An
Coimisiún
Pleanála

Date: 11 March 2026

Re: Proposed construction of 67 no. housing units
on a site at Tyrells Land, situated along Stradbally Road, Portlaoise, Co Laois

Site Area = 2.08Ha
Total Units = 67
Net Developable Area = 1.9Ha
POS = 0.47Ha (21.02%)

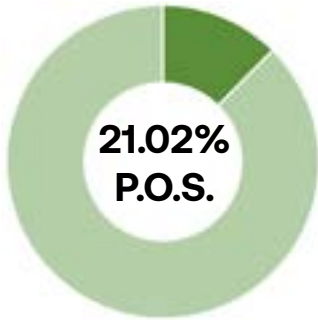
Documents submitted for the planning application contain inconsistencies with respect to the site area, with either an area of 2ha / 2.08ha or 2.8ha stated. A site area of 2ha is specified in the AA Screening Report and NIS, whilst a site area of 2.08ha is stated in sections 4 (pg.21) and 7 (pg.44) of the Architectural Design Statement. The density calculation contained within the Architectural Design Statement has been undertaken on the basis of a site area of 2.0ha, giving a density of 34 dph. However, the site area stated on pages 7 and 22 of the Architectural Design Statement and Schedule of Areas is 2.8ha, which would result in a density of 24 dph.

- (a) Please provide a site plan indicating the areas included in the calculation of the net site area and a corresponding calculation to confirm the proposed density of the development.

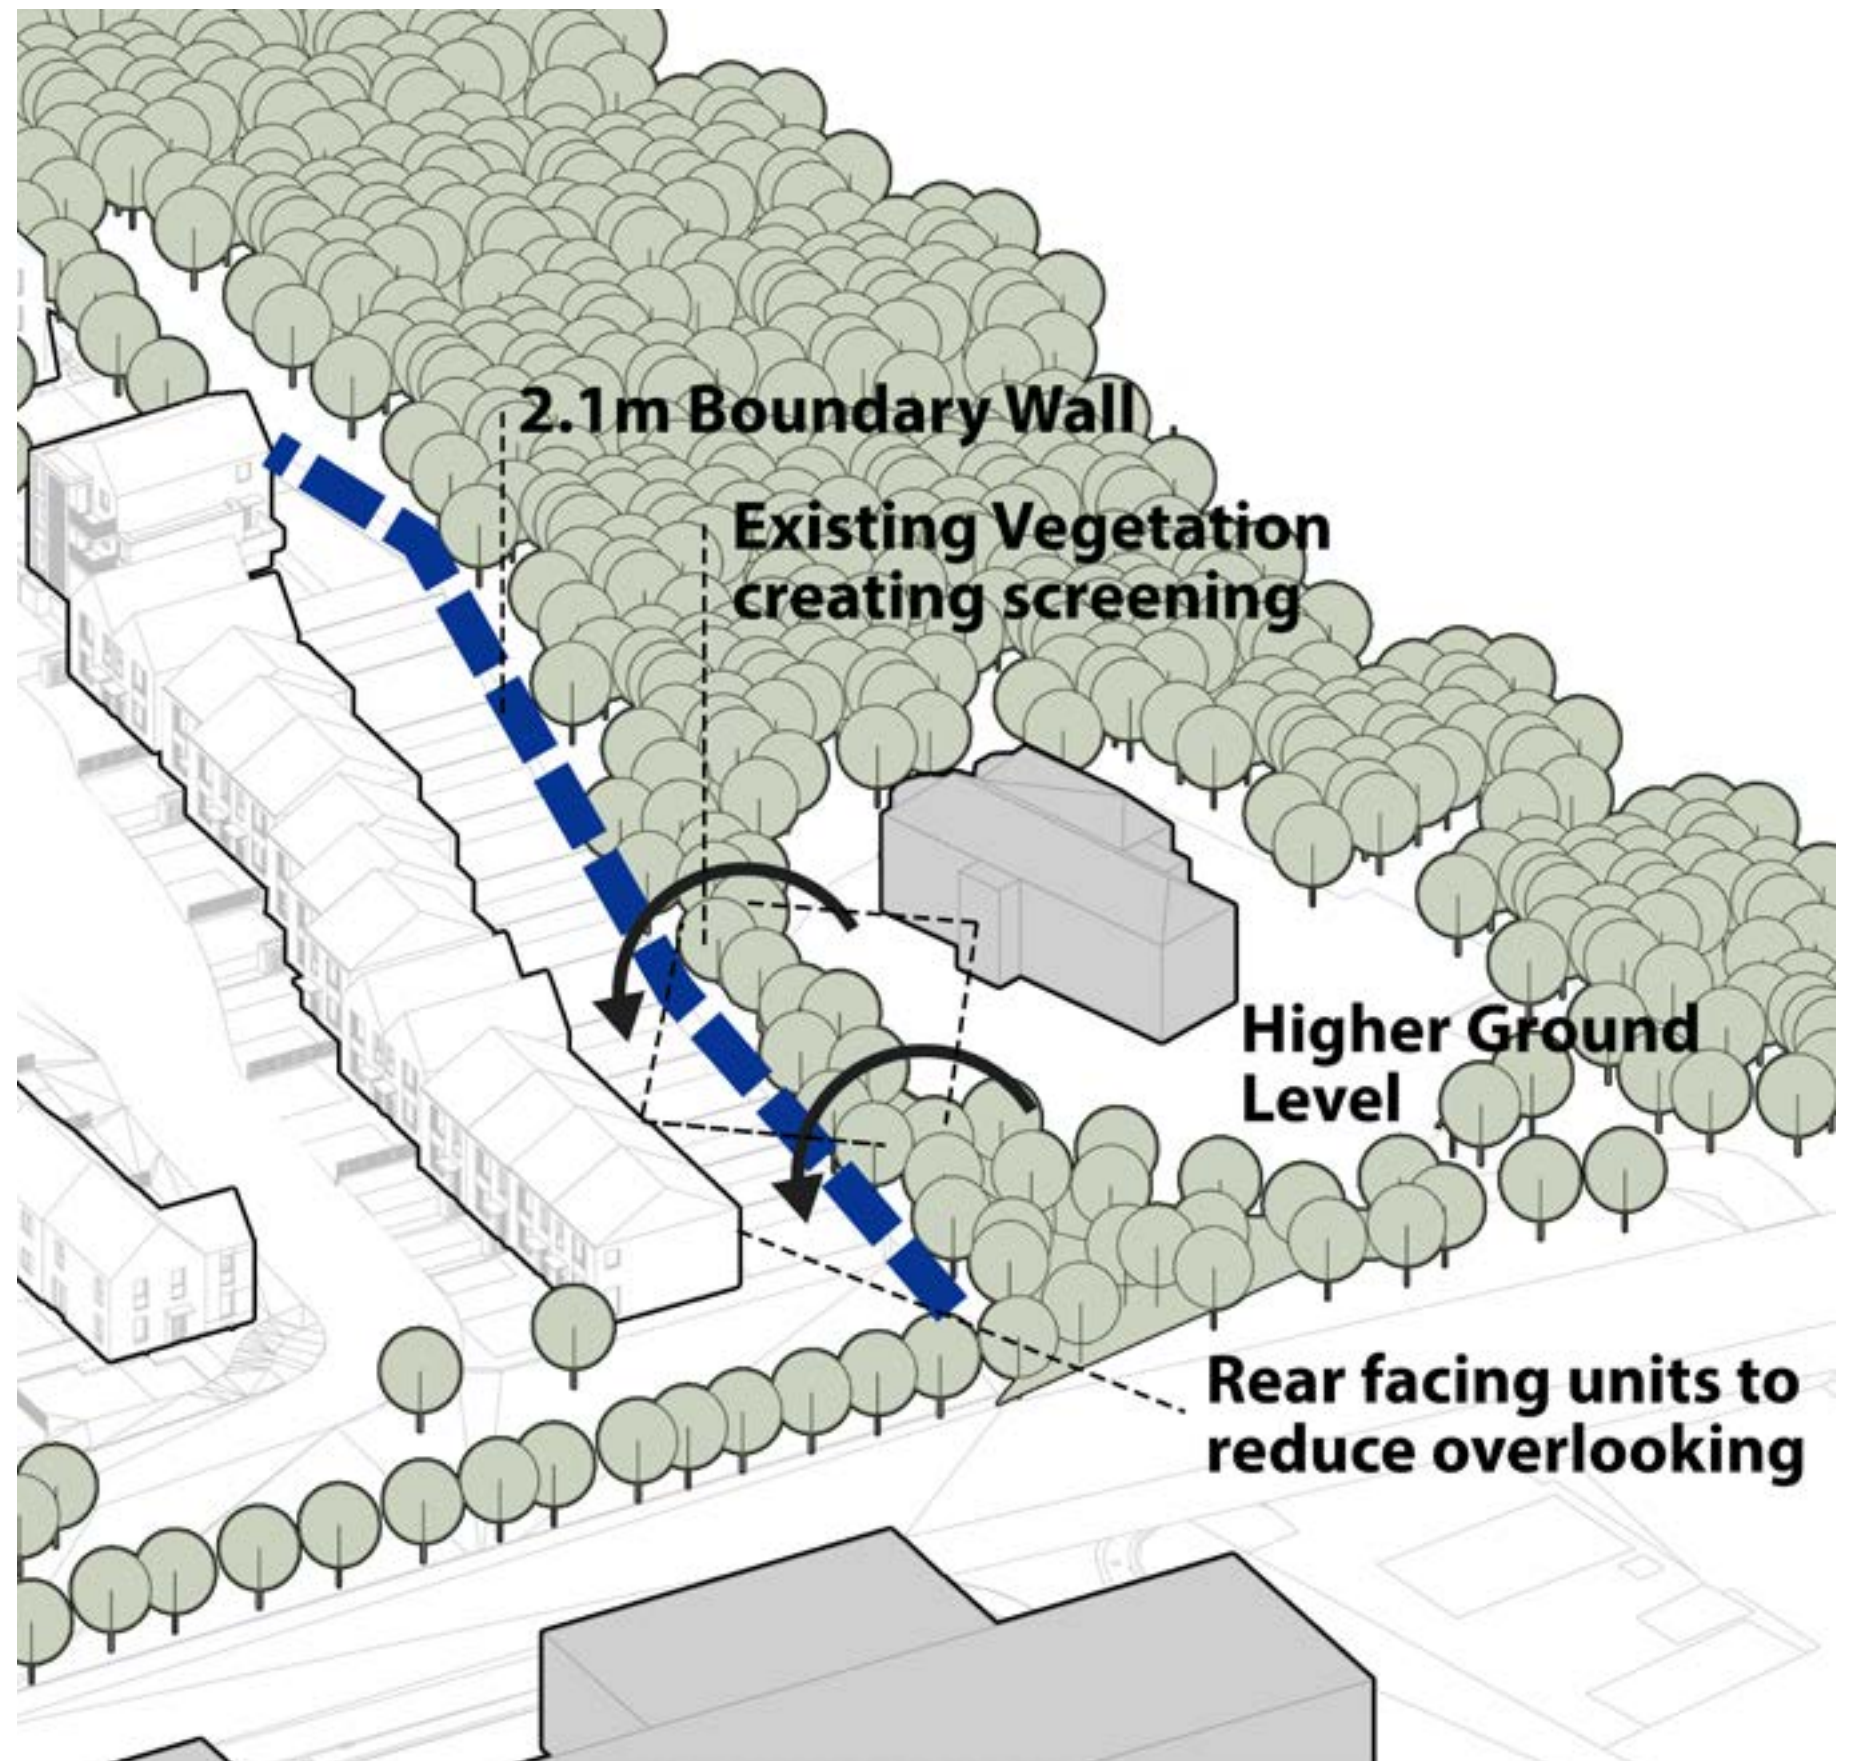
- (b) A copy of the Judith Hill report inclusive of any appendices, should be provided if relied upon as part of the application.
- (c) Please confirm how the layout of the proposed development respects the setting of the protected structure and/or provide amended details with respect to the same.

Figure 5.5: Proposed Stradbally Road/ Internal Access Road junction Layout (Source: Van Dijk Architects)

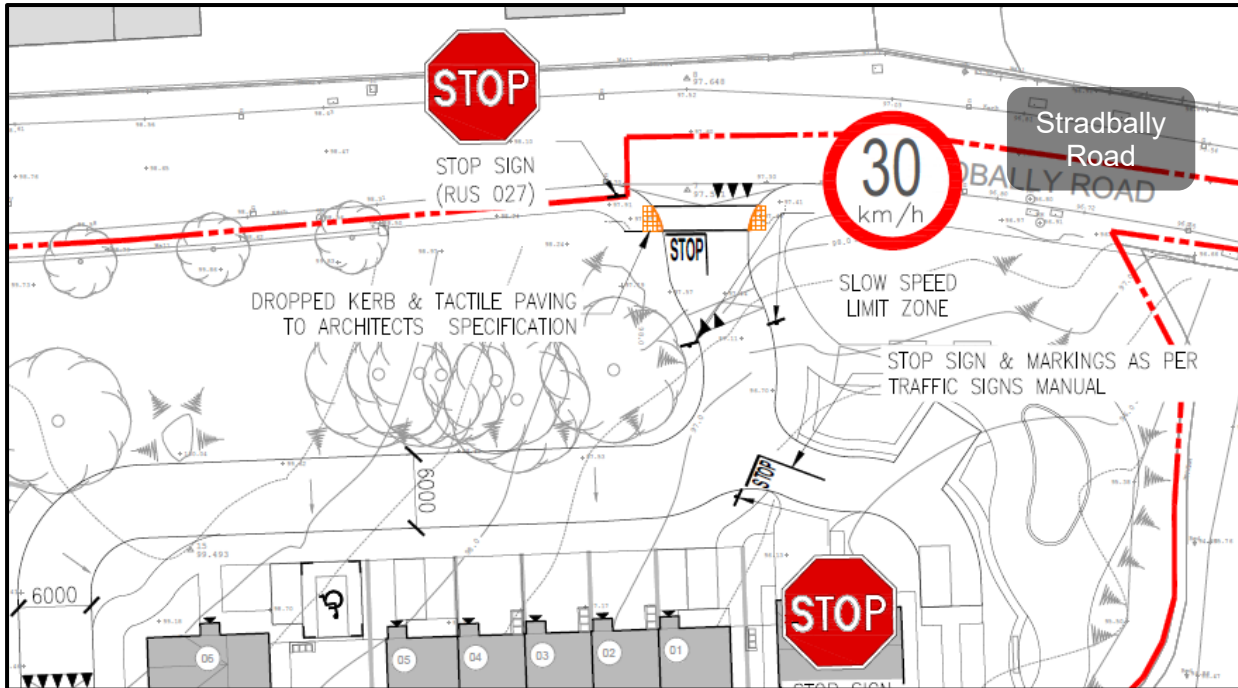
Please prepare a Design Report in consultation with TII with respect to the new junction with the N80 as required by TII Publication (Standards) DN-GEO-03030.
